As an owner of property in the Millers Point Community, I strongly object to the modification of the development to Fort Street Public School.

/ South Elevation Building J/H

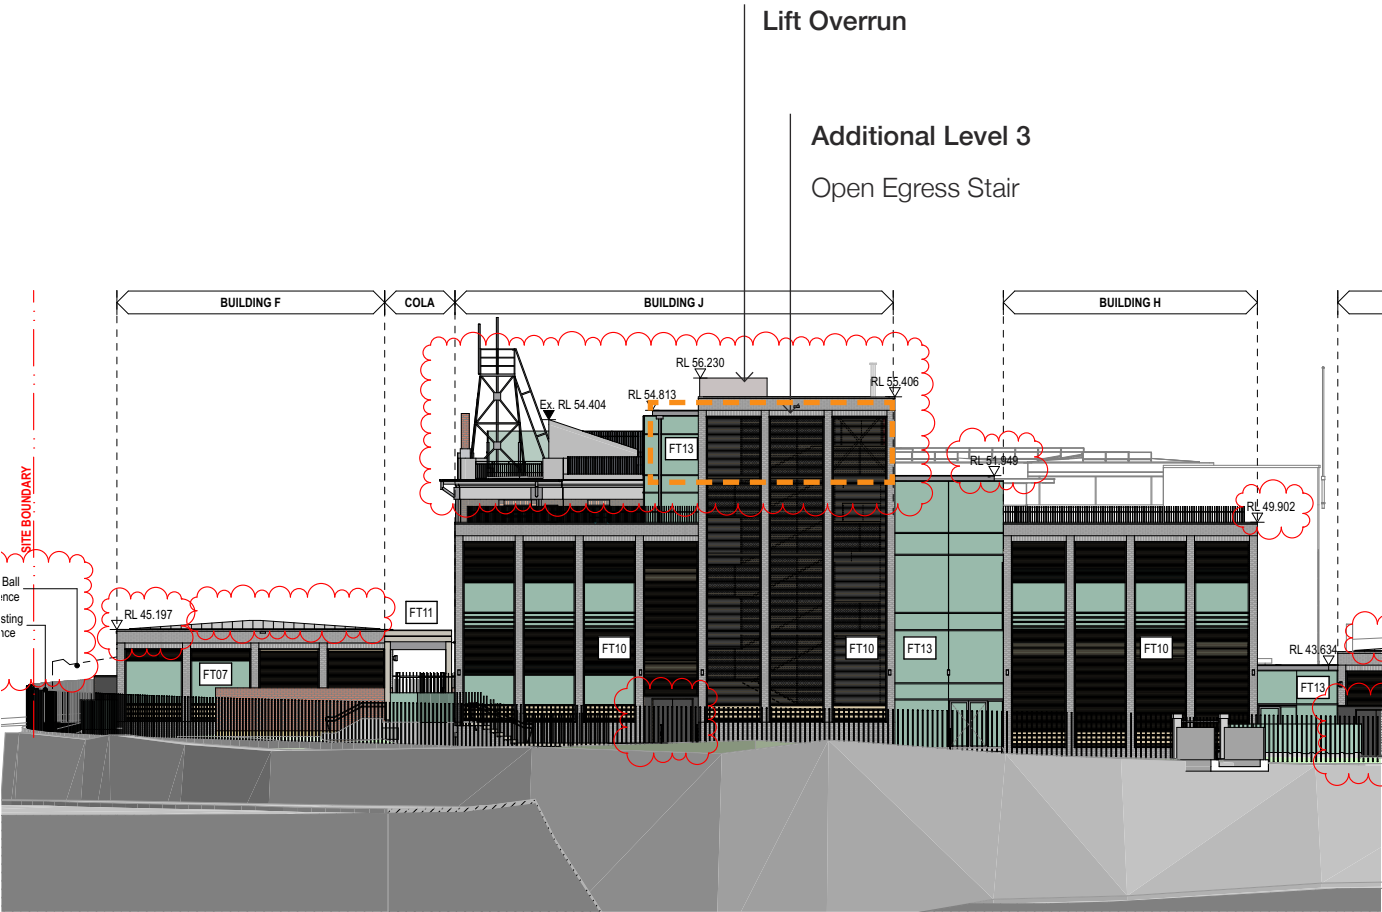
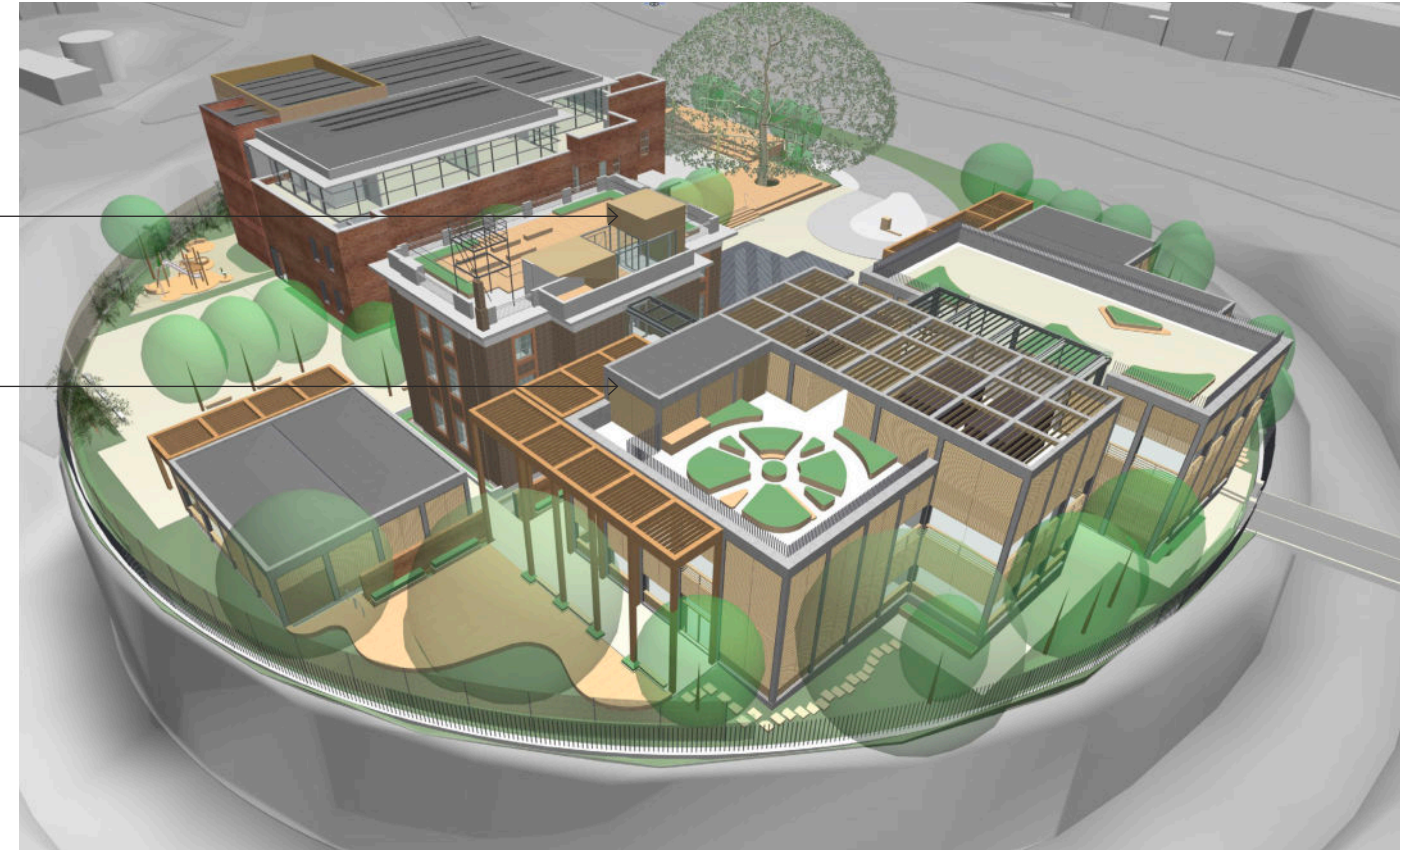
How can Curio Projects on behalf of School Infrastructure NSW say that the increased building height of the Building "J" is compliant to these policies when it is proposed that the new height is well above the parapet of the Met Building? This can be seen in the following diagrams taken from the modification documents where building J is much larger, the general bulk much bigger and it very clearly exceeds the height of the Met building, leaving the Met building to no longer be the most dominant building on site in terms of both height and architectural form.

This is a heritage sight which ultimately needs to be preserved for the good of the people and fit with the surrounding area. This clearly juts out and overbears the Met Building and the site itself.

/ S4.55 - South West View

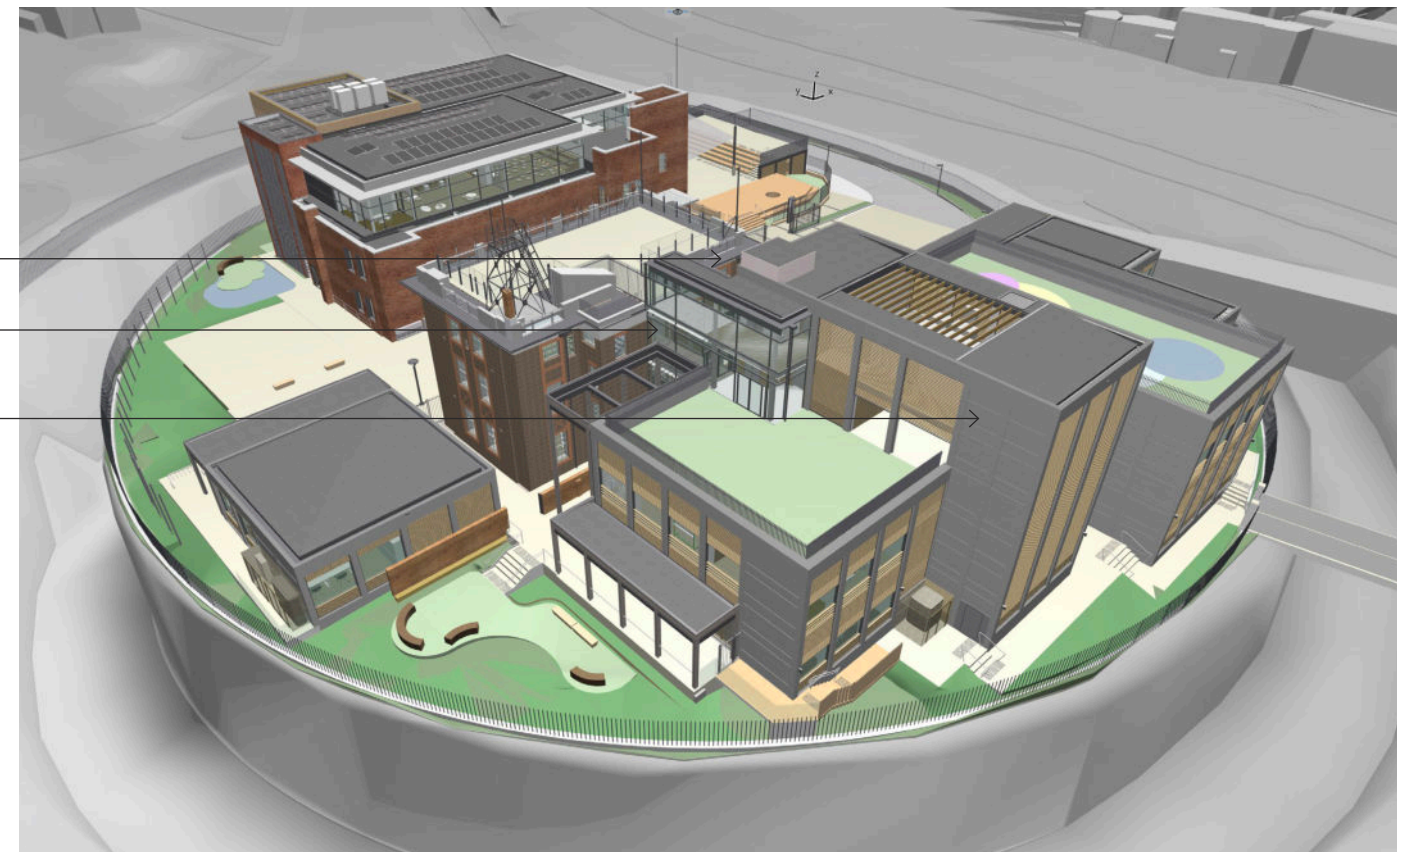
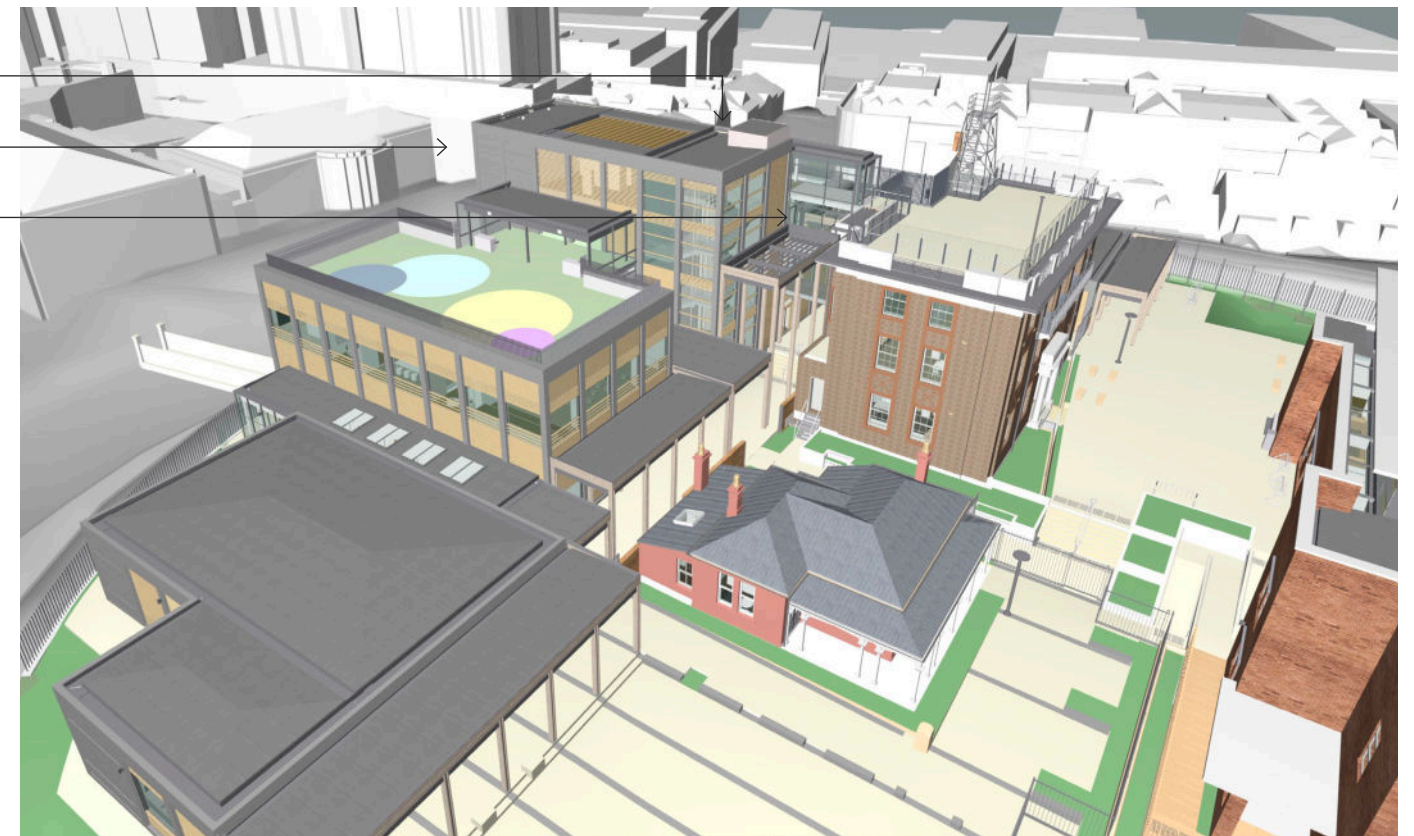
The below diagram also shows the extension to Building J of an additional level makes it the dominant building on the site, taken from the following link (p31):
